**APPLICATION BY LIVERPOOL BAY CCS LIMITED FOR AN ORDER  
GRANTING DEVELOPMENT CONSENT FOR THE HYNET CARBON  
DIOXIDE PIPELINE**

**APPLICATION REF EN070007  
PIBLINELL CARBON DEUOCSID HYNET /  
HYNET CARBON DIOXIDE PIPELINE**

**FLINTSHIRE COUNTY COUNCIL'S RESPONSE TO THE  
TO THE EXAMINING AUTHORITY'S ISSUE SPECIFIC HEARING  
ACTION POINTS ISH1-AP4 (3): FLOOD RISK MANAGEMENT  
APPENDIX 1**

**SUBMITTED AT DEADLINE 4 – TUESDAY 20 JUNE 2023**

WATERCOURSE CROSSINGS

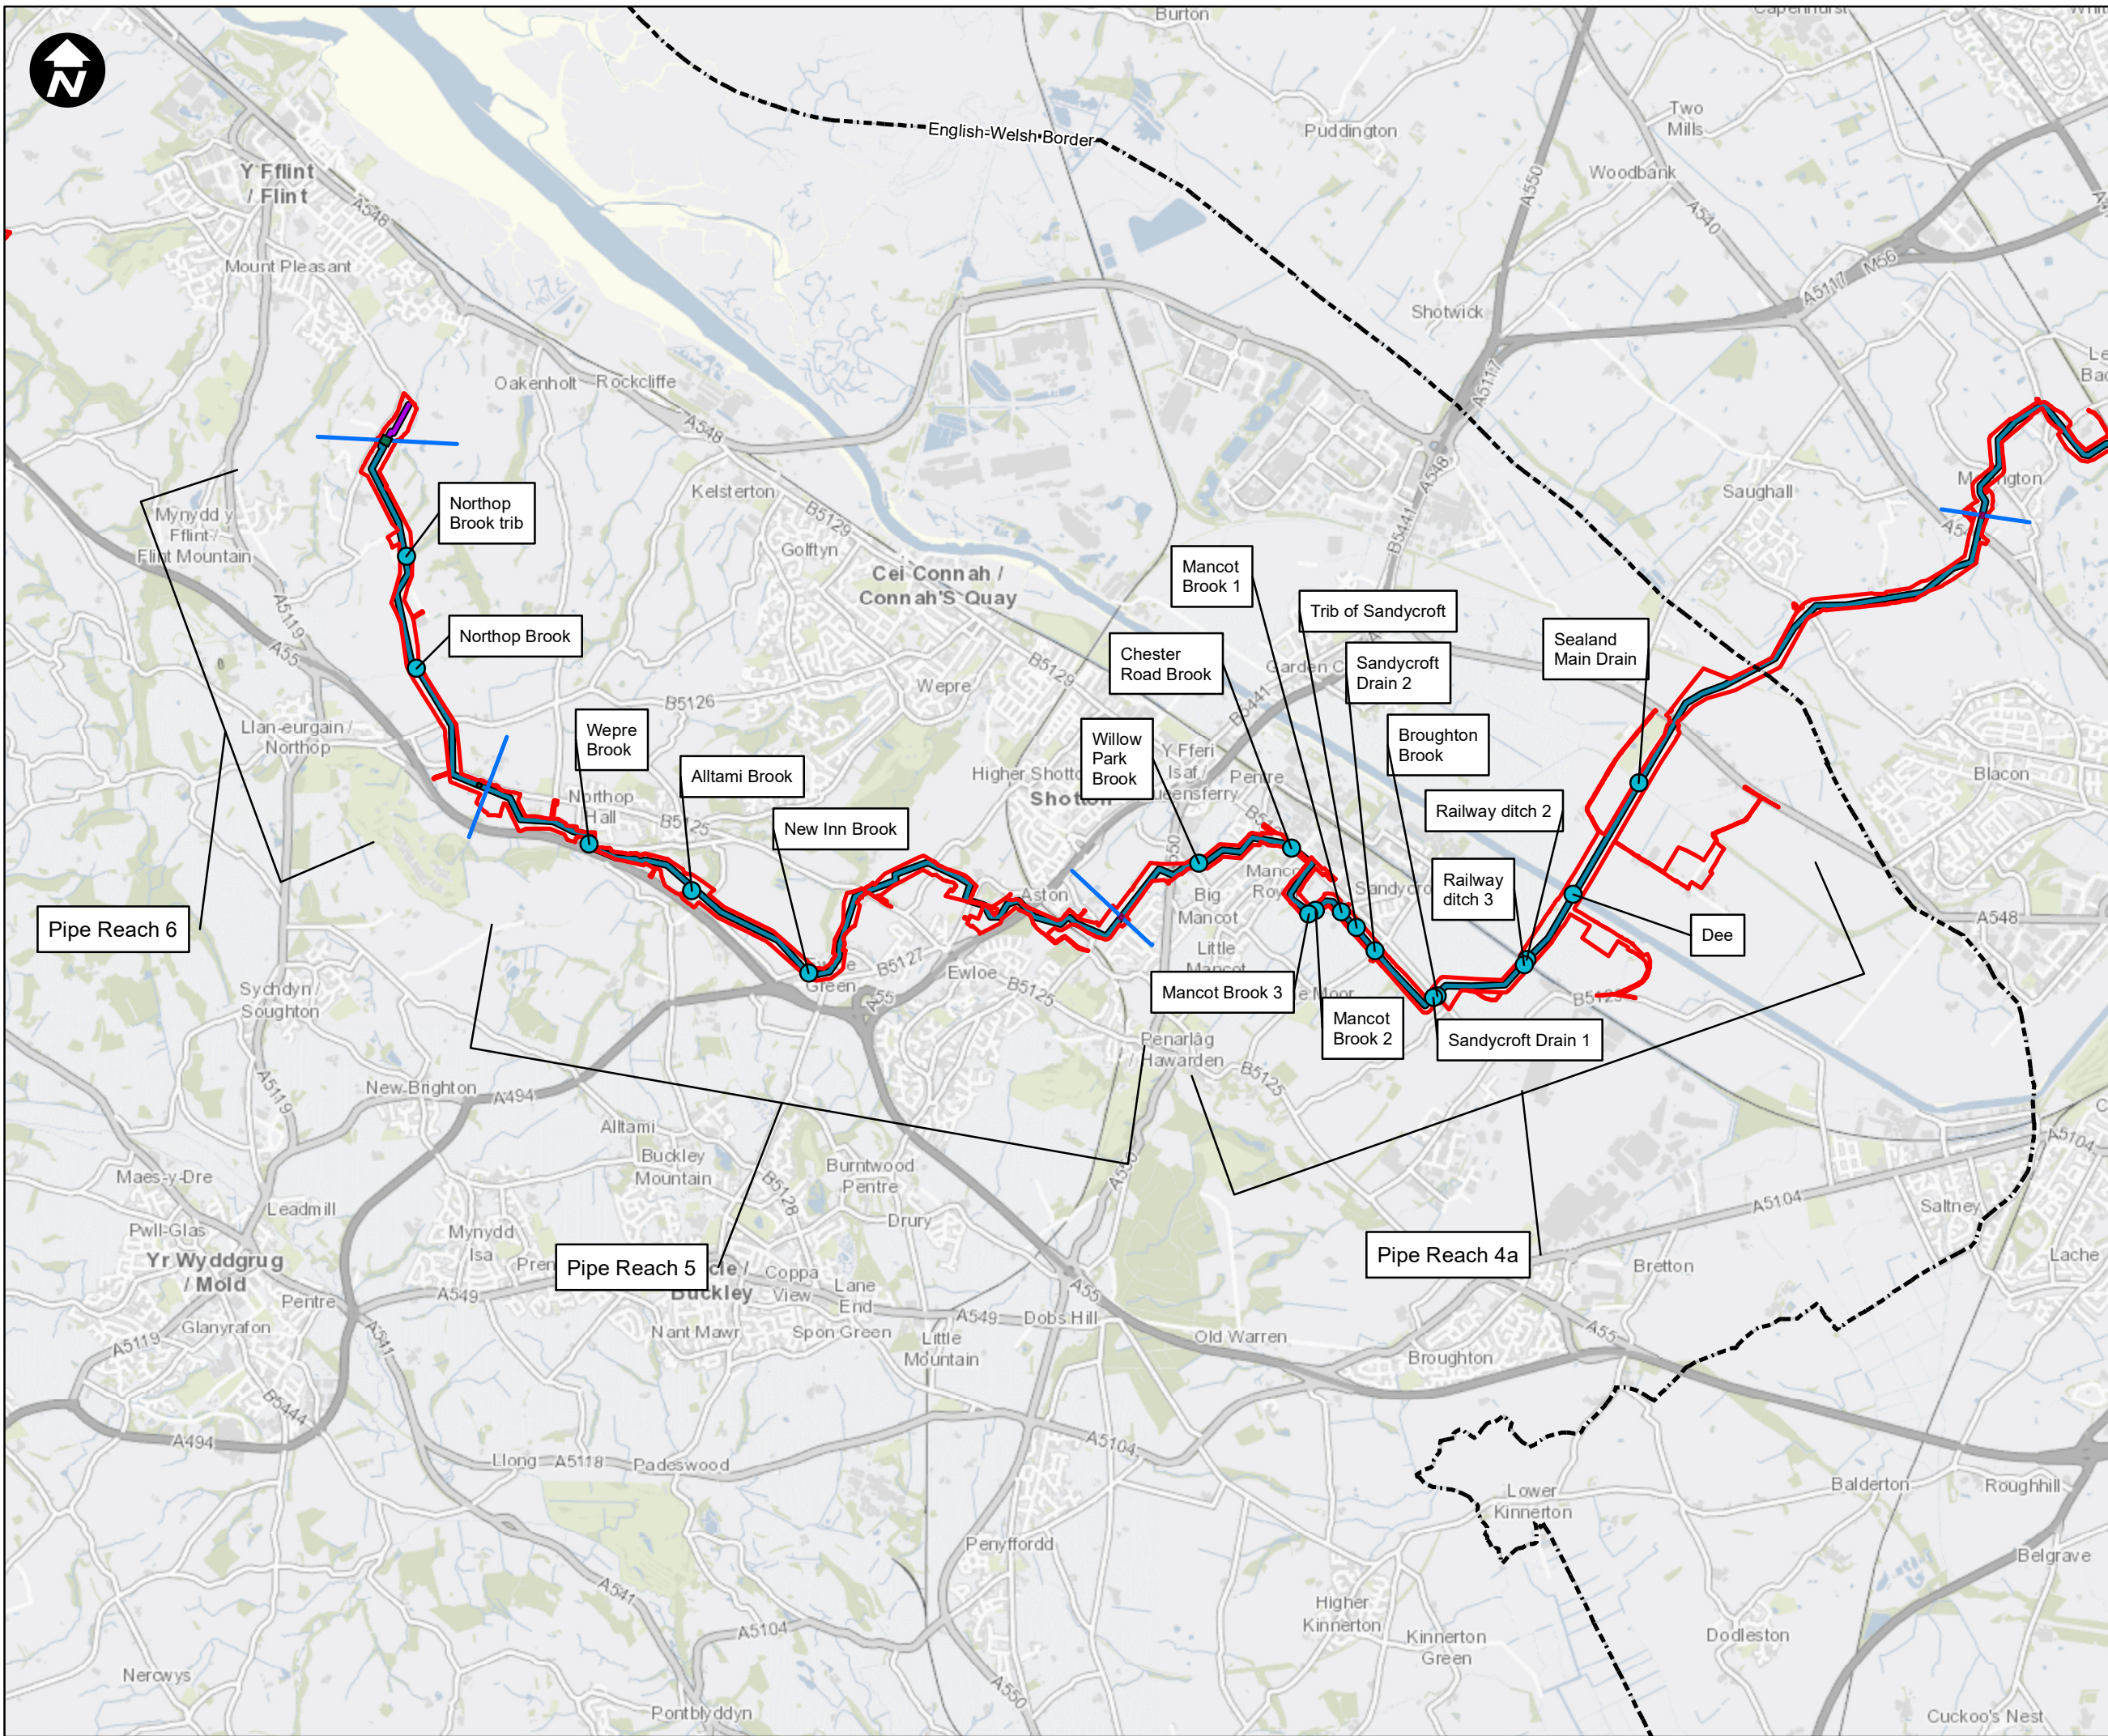
- 1.3 Following a review of the submitted documentation, to protect our interests FCC currently have the following comments.
- 1.4 Document **D.6.3.18.5 FCA Part 1 Rev A Table 1 Watercourse Crossings [APP-168]** on Page 17 states there are 12 Ordinary Watercourse crossing/intersection points within Flintshire. It may be suggested that following further site investigation and excavation works as the scheme progresses, further culverted ordinary watercourses may be discovered. There are several significant ordinary watercourse crossings within the proposals that possess known areas of surface water flood risk associated. It is considered that there is insufficient information within FRA, surface water drainage strategy or the **D.6.5.4 Outline Construction Environmental Management Plan (OCEMP) [APP-228]** evidenced at this time to fully understand and assess the impacts that the pipeline and associated works would have on the watercourse both for temporary and permanent works.

1.5 In order to fully assess the impact and risks of the works on the intersections of ordinary watercourse, FCC would request the below detail be provided where practically possible. The below is a summary of what FCC as LLFA would typically request as part of any land drainage consent application.
